Quorn Park Solar Farm (SSD-9097) Request for Additional Information

I refer to assessment of Quorn Park Solar Farm (SSD-9097). After careful consideration, the Department is requesting that you provide additional information.

CLIENT	QUORN PARK SOLAR FARM PTY LTD		
PROJECT	QUORN PARK SOLAR FARM		
LOCATION	PARKES, NSW 2870	SHEET NUMBER	REV
SHEET TITLI	C001	C

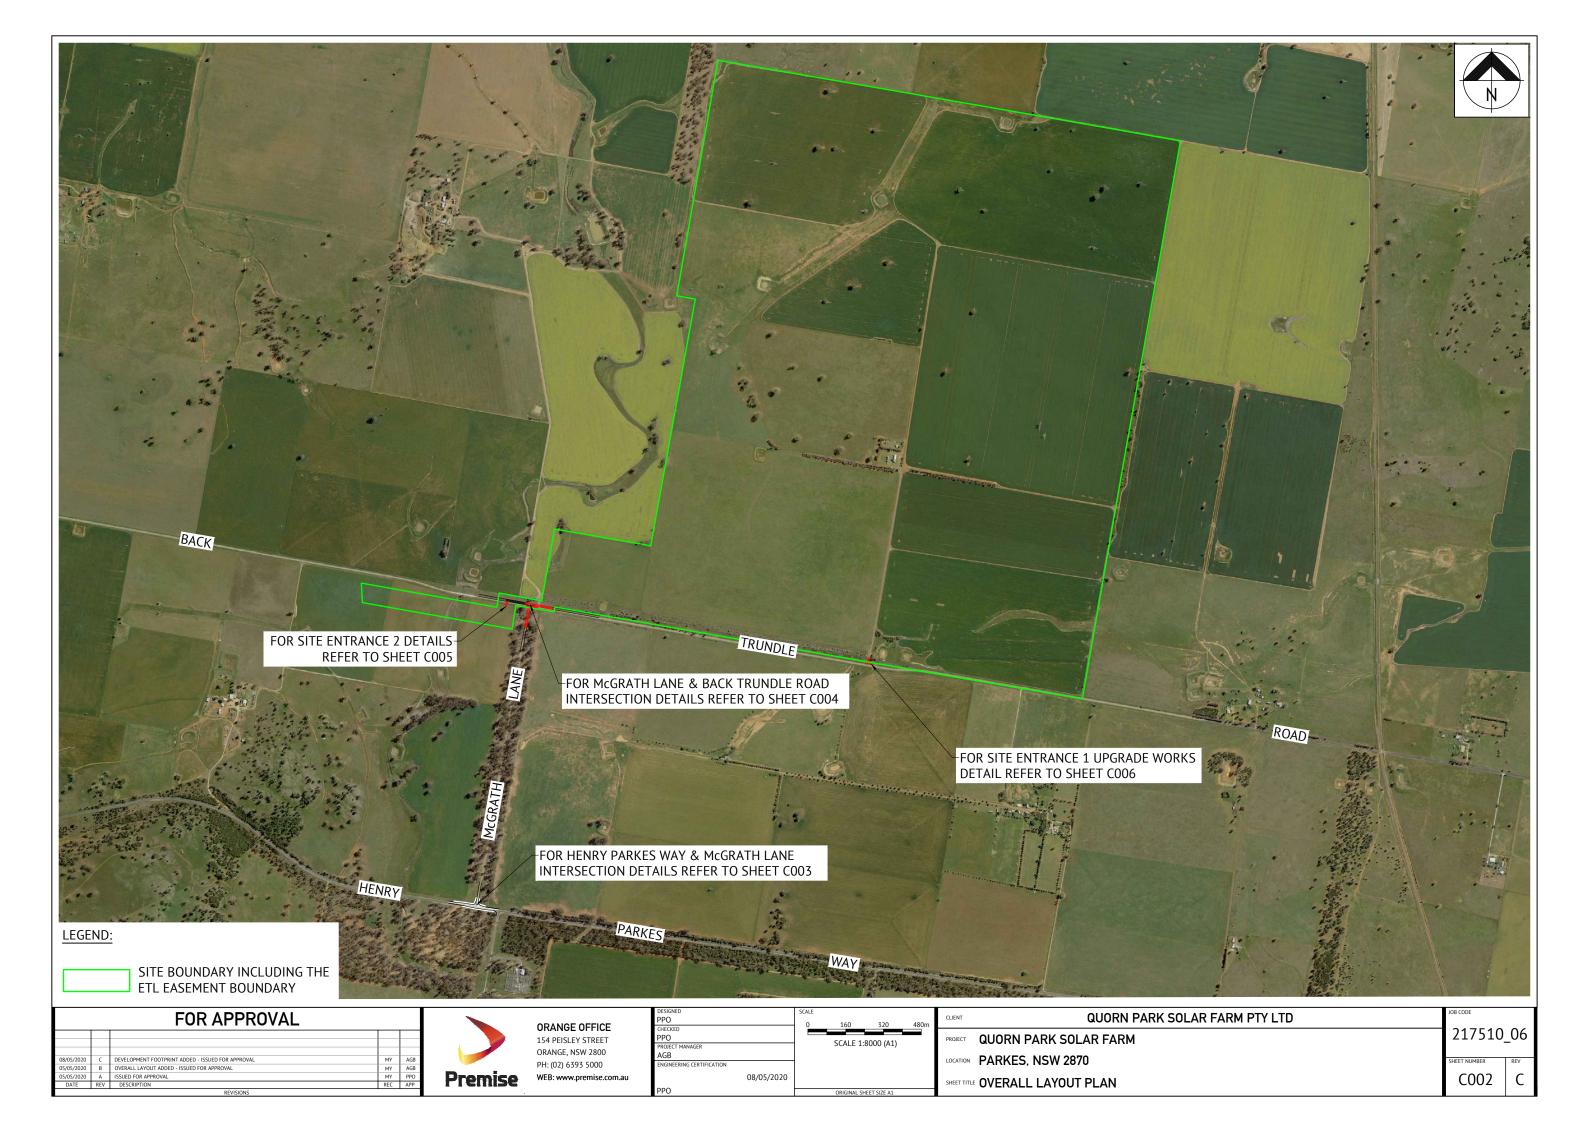
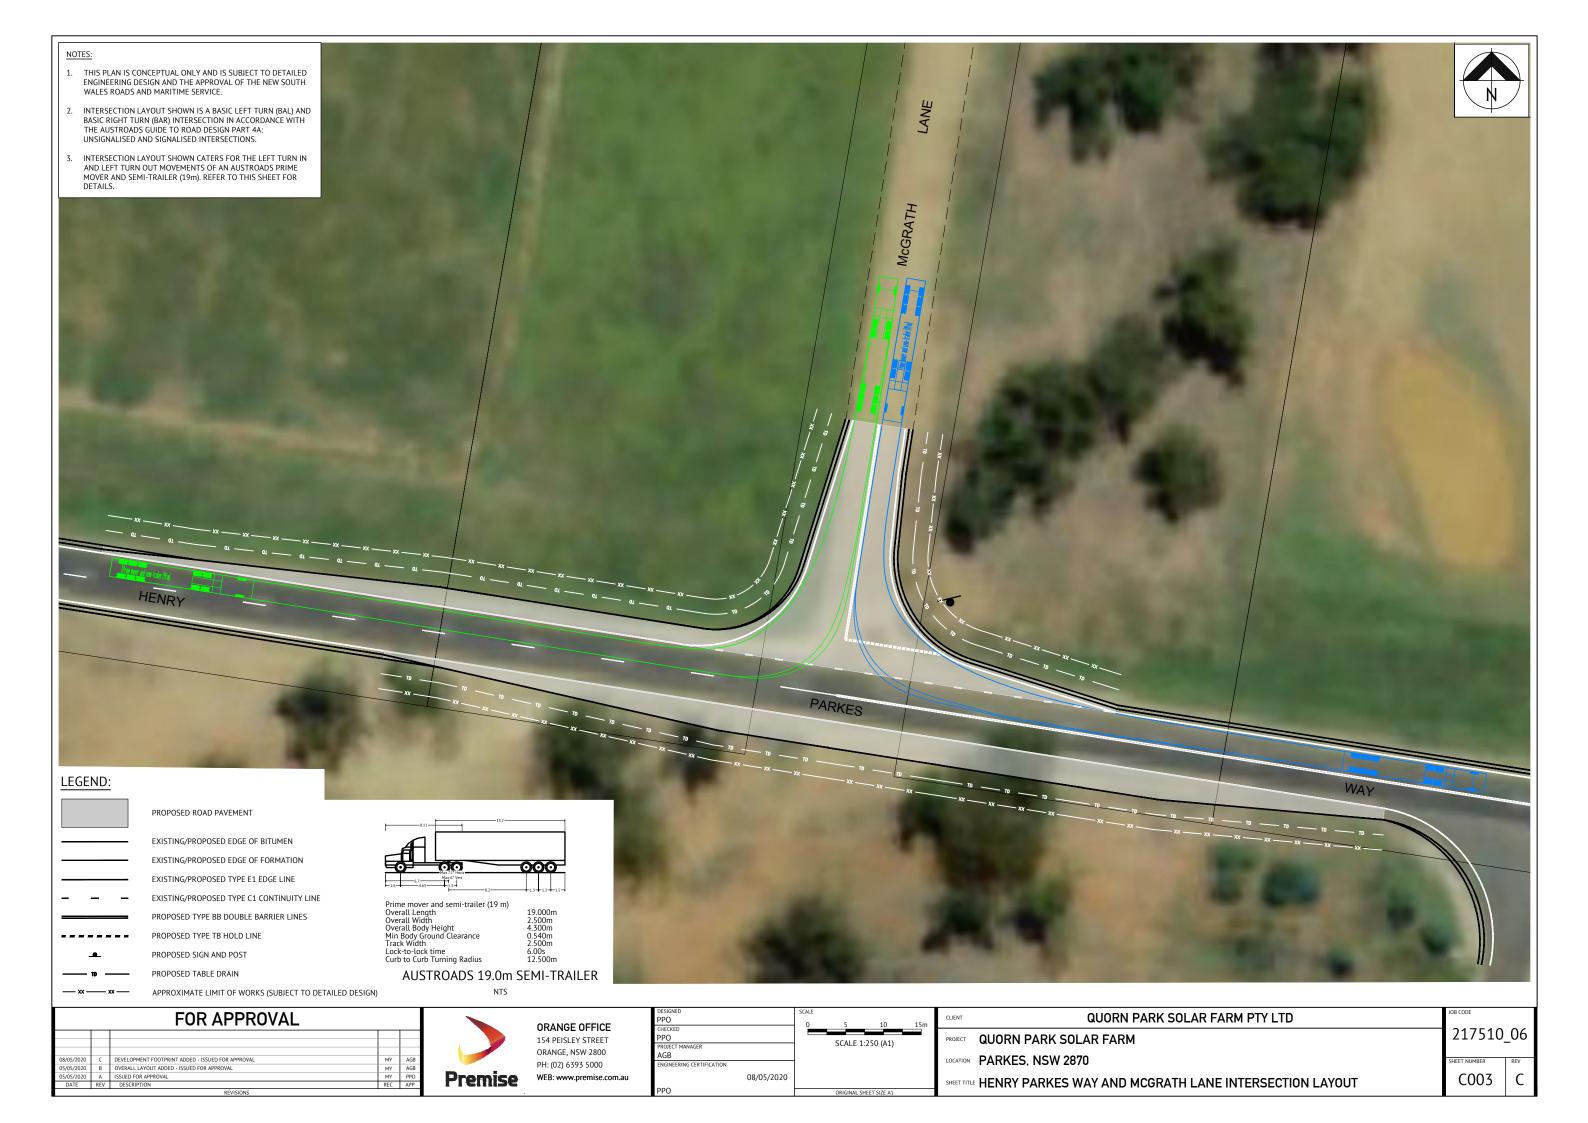
- clarify the nature and location(s) of the intersection upgrades and intersection treatment types, and include a swept path diagram for the largest vehicles travelling to and from the site;
- clarify all proposed road alignment upgrades, including type of road treatment (gravel / asphalt) and length and width of treatment;
- provide an updated figure identifying where all intersection and road upgrades are proposed;
- confirm route and access points to the transmission line and associated infrastructure, including any road and/or access point upgrades required;
- provide an assessment of any upgrades (including biodiversity and heritage) that are not included in the application to date and identify any additional land parcels which may be affected due to the proposed road upgrades, including landowner consent for additional land parcels (if required).
